Planning and Development Department
Lee D. Urban, Director

April 8, 2005

RE: Application for Single Family Residences, Ruby Lane lots #1, 2, and 17

Upon review of the site plans, the City's Planning Division has the following comments:

LOT 17 LAYOUT & UTILITIES PLAN

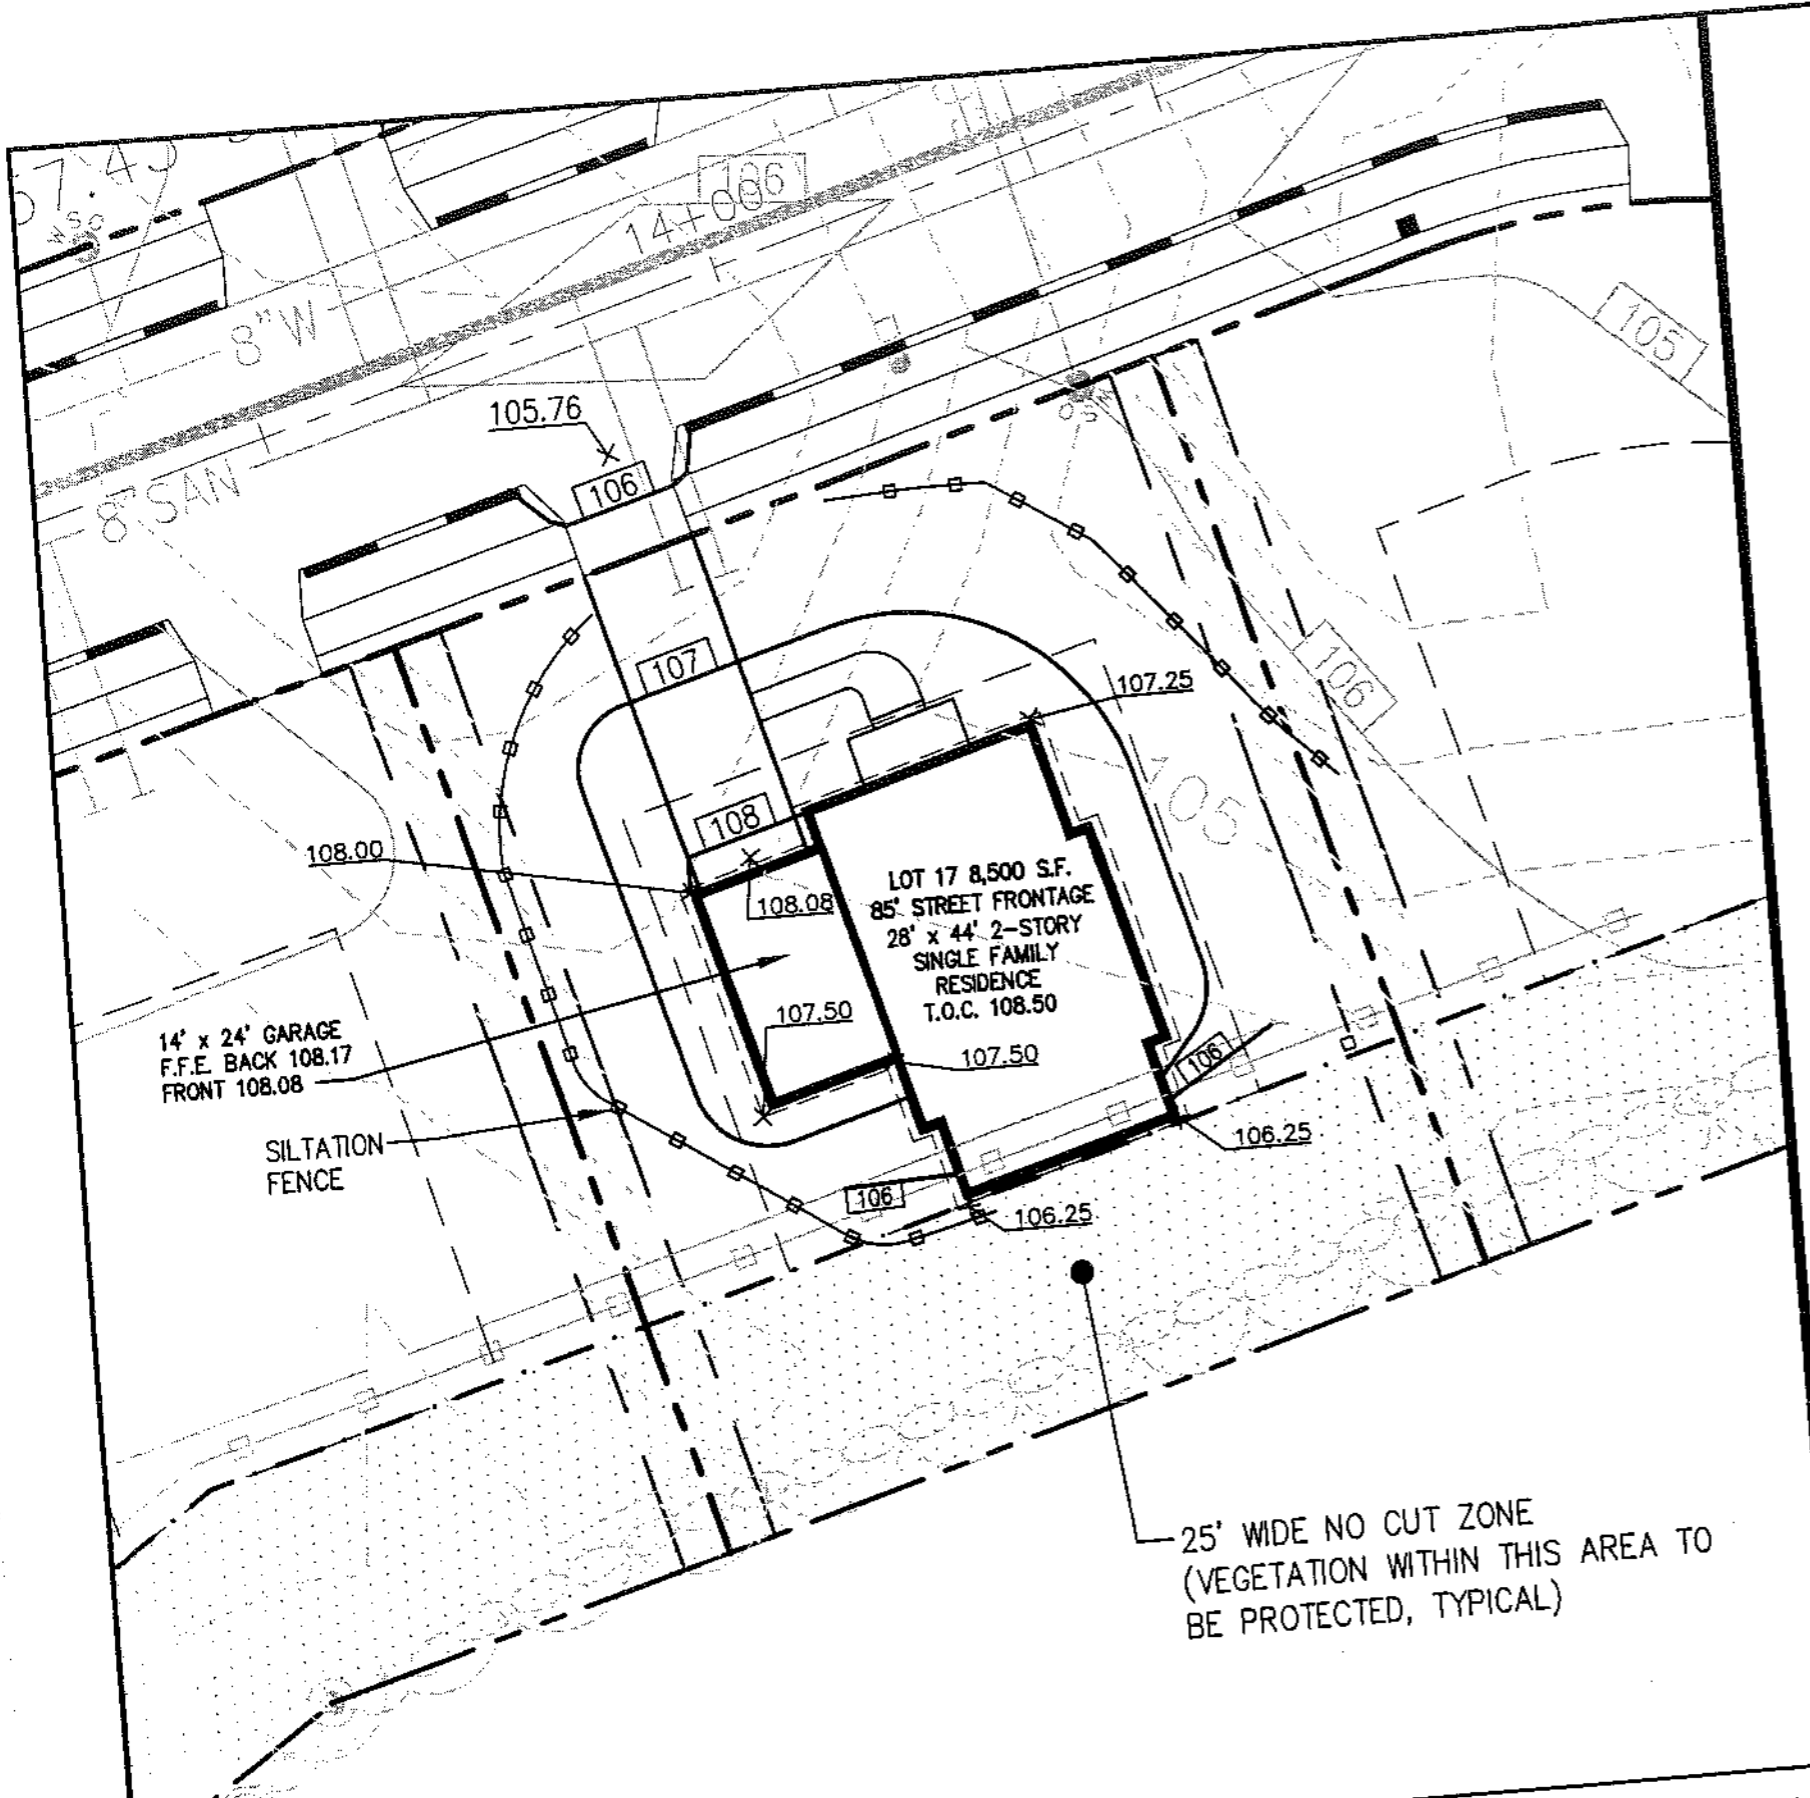
1. This application is not showing the required 2 parking spaces outside of the front setback. Please revise.

LOT 1 LAYOUT & UTILITIES PLAN

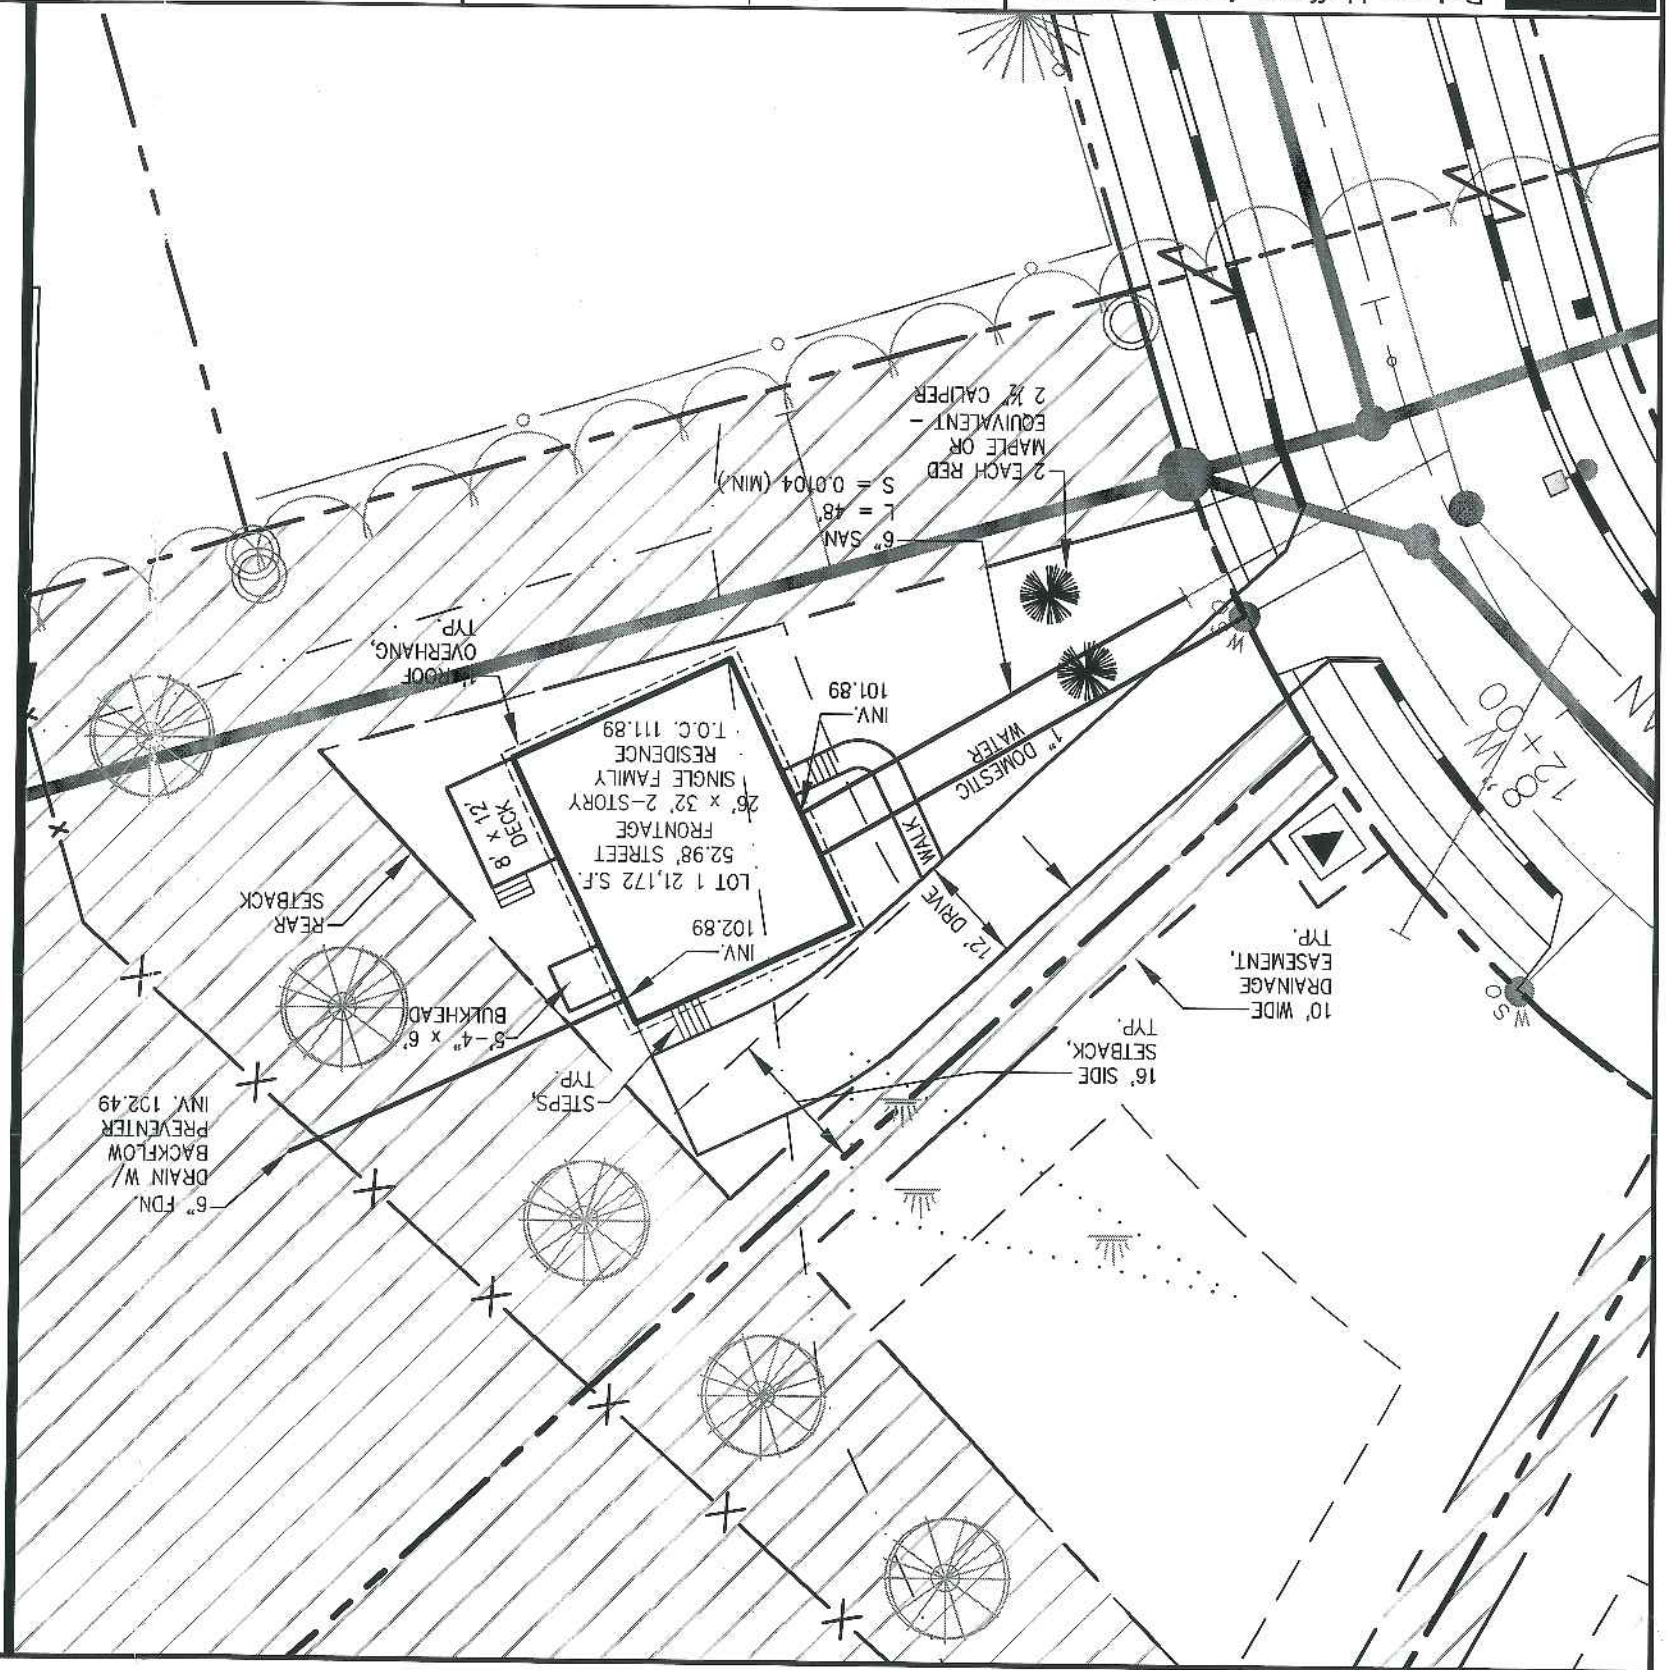
1. The submittal does not conform to the minimum elevations set forth in the subdivision approval. The approved top of concrete elevation for lot 1=106.00. The daylight basement feature does not meet this criterion.
2. The daylight feature cutting into the side-slope of the detention area also does not conform to the approved grading and topography.
3. Although the daylight basement elevation is above the 25-year flood elevation, it may not be above the 100-year flood elevation. Regardless, I would not support this design/buildout due to its' relation to the detention pond.
4. The site plan shows a retaining wall within the drainage easement. This would violate article C of the drainage easement.
